**Planning Act 2008 – Section 88 and the Infrastructure Planning (Examination Procedure) Rules 2010 – Deadline 6: Comments on Applicant's revision 5 draft DCO**

**Application by NNB Generation Company (SZC) Limited for an Order Granting Development Consent for the Sizewell C Project**

## Appendix A: Environment Agency comments on Draft Development Consent Order

DRAWING NO:
SZC-SZ0100-XX-000-DRW-100205

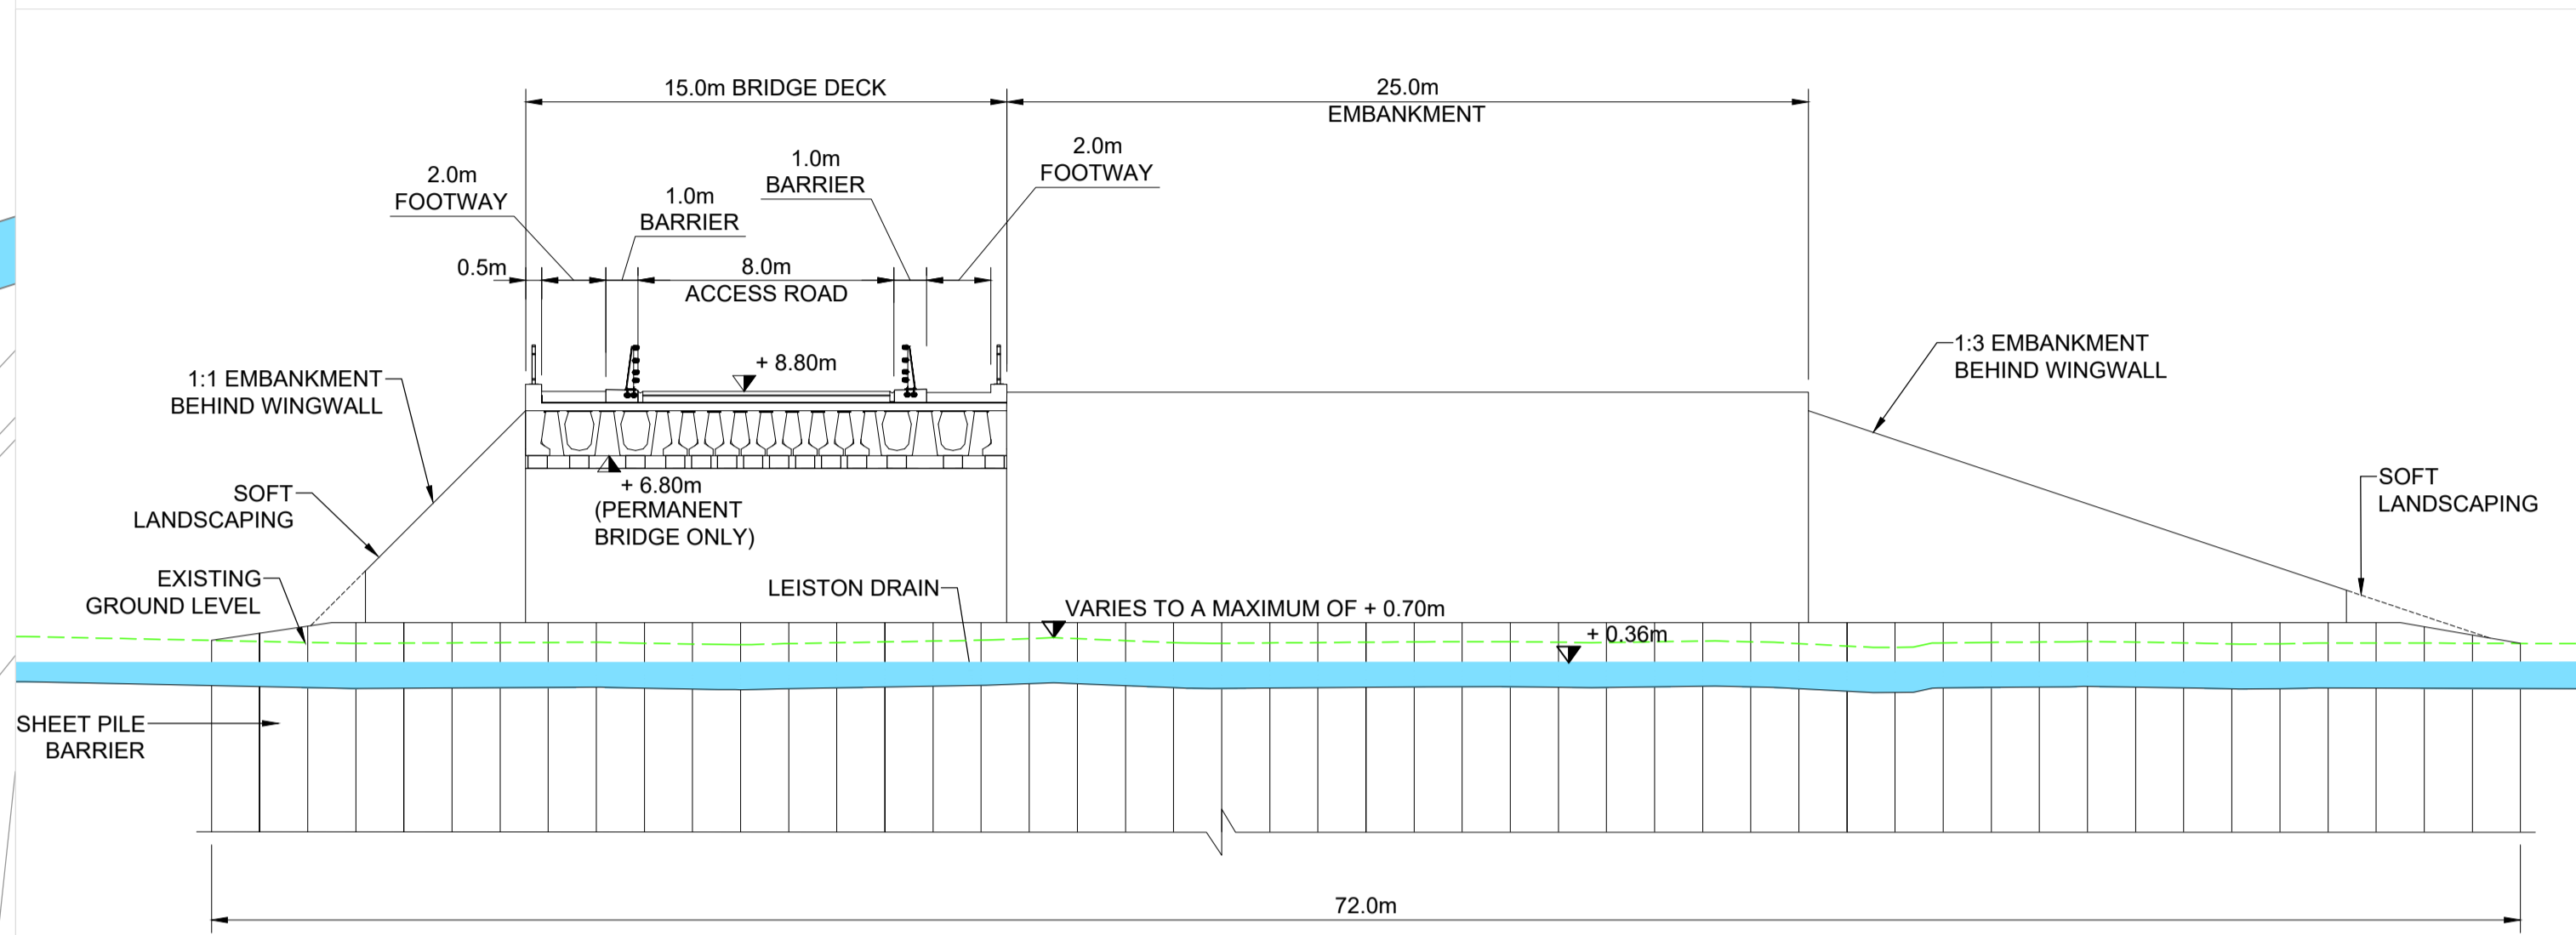
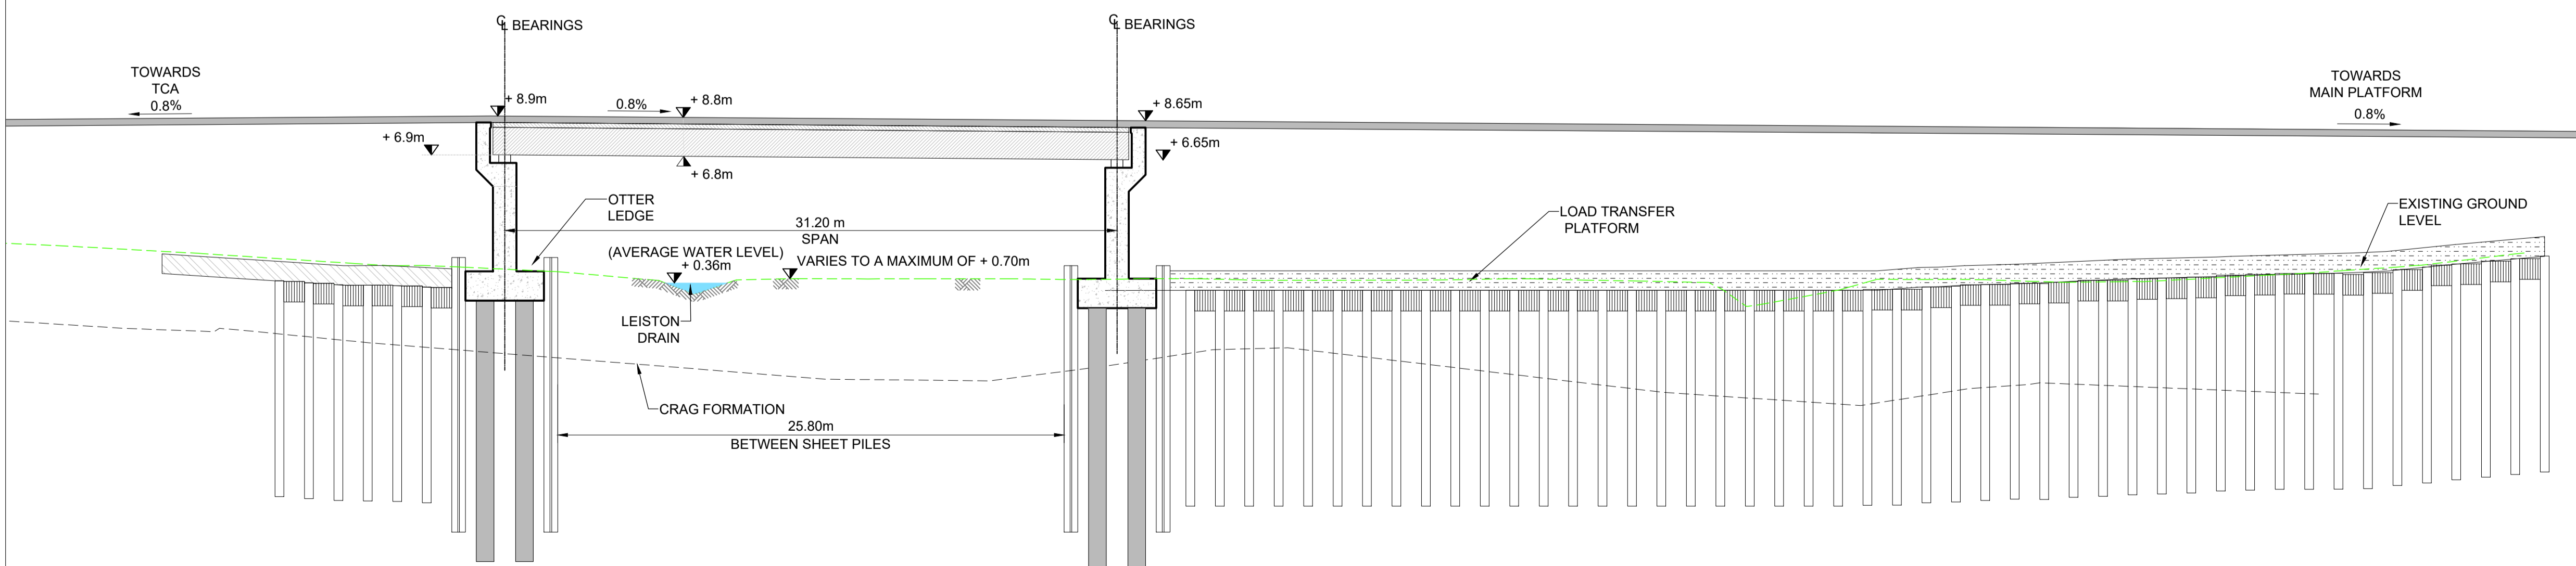
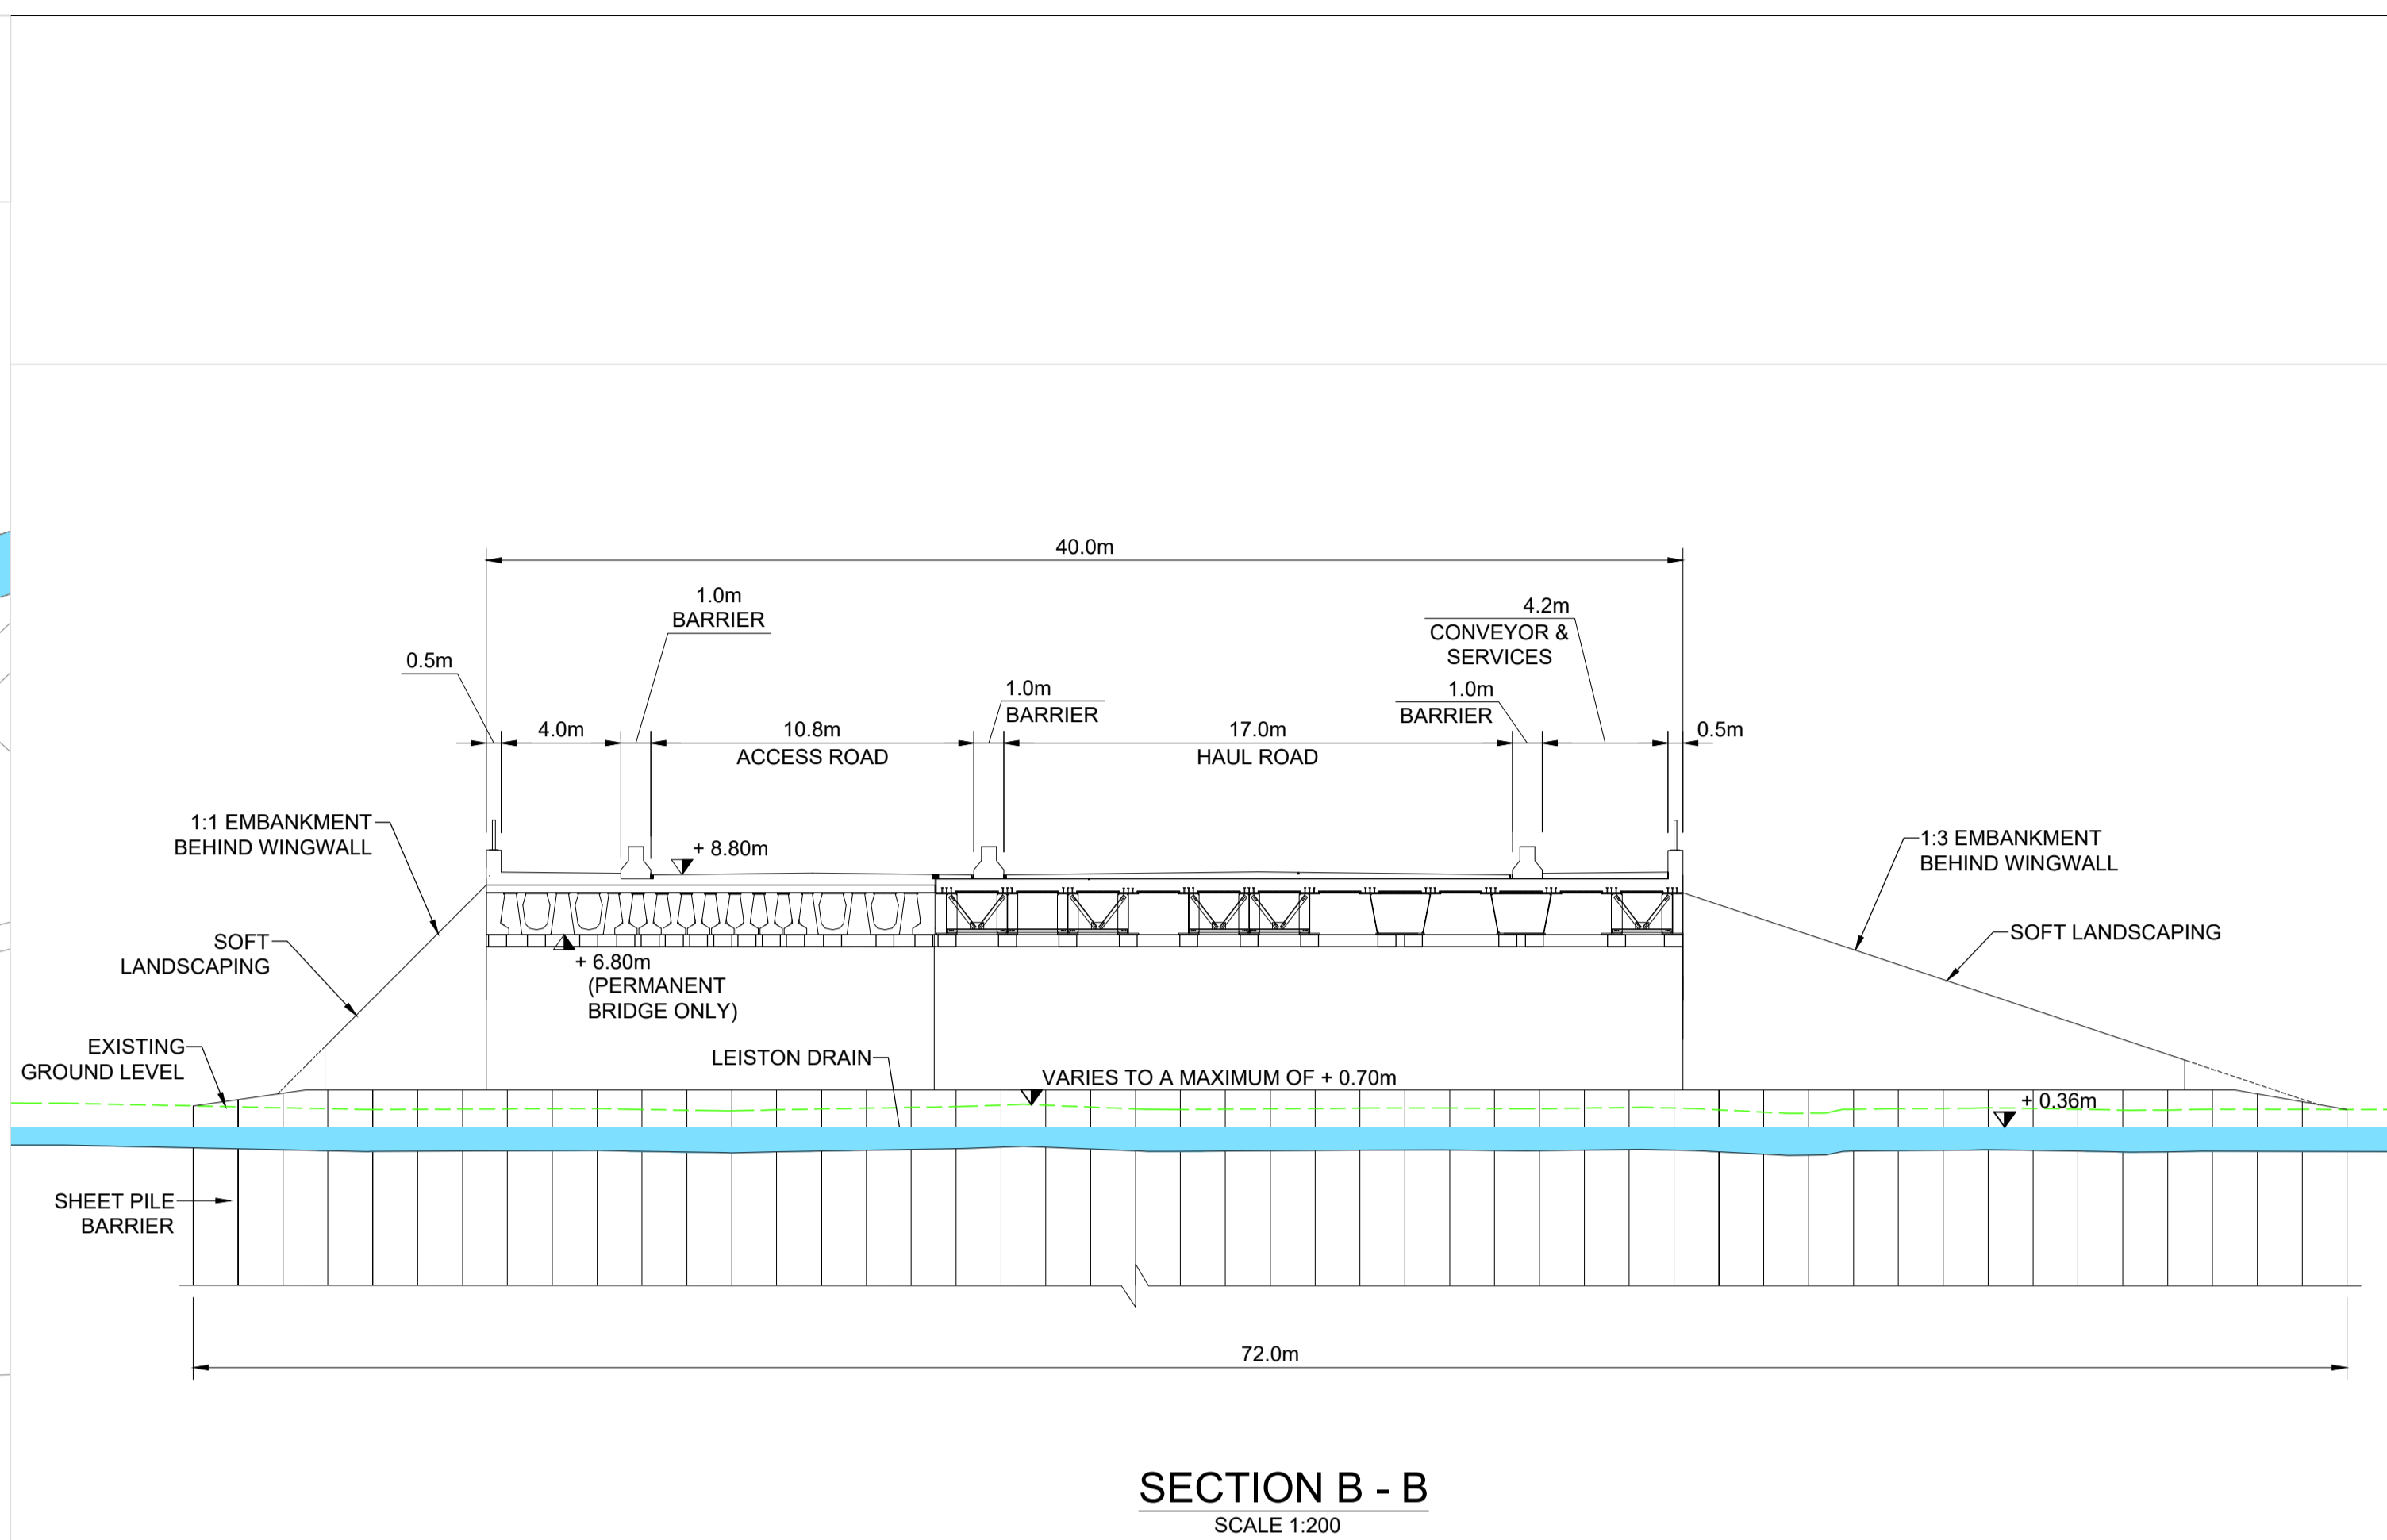
Section	Wording	Comments
<b>Schedule 2, Article 3 - Requirements</b>		
Requirement 12C,  Main development site: SSSI Crossing	<p><b>Main development site: SSSI Crossing</b></p> <p>(1) Construction works within the SSSI must not commence until details of working methods within the SSSI land have been submitted to and approved by East Suffolk Council, following consultation with Natural England. The temporary SSSI Crossing must be built in general accordance with the following details:</p> <p>(a) Main Development Site SSSI Crossing (SZC Construction) (July 2021) (Drawing Ref: SZC-SZ0100-XX-000-DRW-100207 (Rev. 02));</p> <p>(b) Main Development Site SSSI Crossing (Bailey Bridge Stage) (July 2021) (Drawing Ref: SZC-SZ0100-XX-000-DRW-100209 (Rev. 02)).</p> <p>(2) Construction of the permanent element of Work No. 1A(I) (SSSI Crossing) must not commence until details of the layout, scale and external appearance have been submitted to and approved by East Suffolk Council, following consultation with the Environment Agency and Natural England. The details must:</p> <p>(a) be in general accordance with the Main Development Site SSSI Crossing (SZC Operational) (July 2021) (Drawing Ref: SZC-SZ0100-XX-000-DRW-100205 (Rev. 02));</p> <p>(b) include layout and scale which has:</p> <p>(i) a crest no lower than 8.6m (AOD);</p>	<p>The potential environmental impacts, including Water Framework Directive concerns, relate to both the construction and permanent elements of the SSSI Crossing.</p> <p>On this basis, we request that the Environment Agency is a consultee in discharging (1) Construction works, as well as for (2) permanent elements.</p>

<p>(ii) a soffit no lower than 6.8m (AOD) at its intersection with the Leiston Drain; and</p> <p>(iii) a span no wider than 15m.</p> <p>(c) include a flood risk monitoring and adaptive defence plan that sets out the periodic monitoring proposals for the SSSI Crossing and the trigger point for when the crest height of the SSSI Crossing would need to be increased to 10.5m (AOD).</p> <p>(d) a timetable for the works, including a timetable for the return of temporary SSSI land.</p> <p>(3) Work No. 1A(I) (SSSI Crossing) must be carried out in accordance with the approved details.</p>	
<p>Requirement 22A,</p> <p>Associated developments: Landscape works</p>	<p><b>Associated developments: Landscape works</b></p> <p>(1) Work No. 11 and Work No. 12 must not be commenced until details of the landscape works for that work have been submitted to and approved by East Suffolk Council.</p> <p>(2) The details referred to in paragraph (1) must be in accordance with the Approved Plans (Schedule 7), unless otherwise agreed by East Suffolk Council.</p> <p>(3) Landscape works must be carried out in accordance with the approved details.</p> <p>(4) landscape works in relation to Work No. 11 must be managed in accordance with the Two Village Bypass Landscape and Ecology Management Plan, unless otherwise agreed with East Suffolk Council.</p>	<p>This requirement secures key environmental mitigation and monitoring measures.</p> <p>On this basis, we request the requirement is amended so the Environment Agency is a consultee any future revision of Sizewell Link Road or Two Village Bypass Landscape and Ecology management plans.</p>
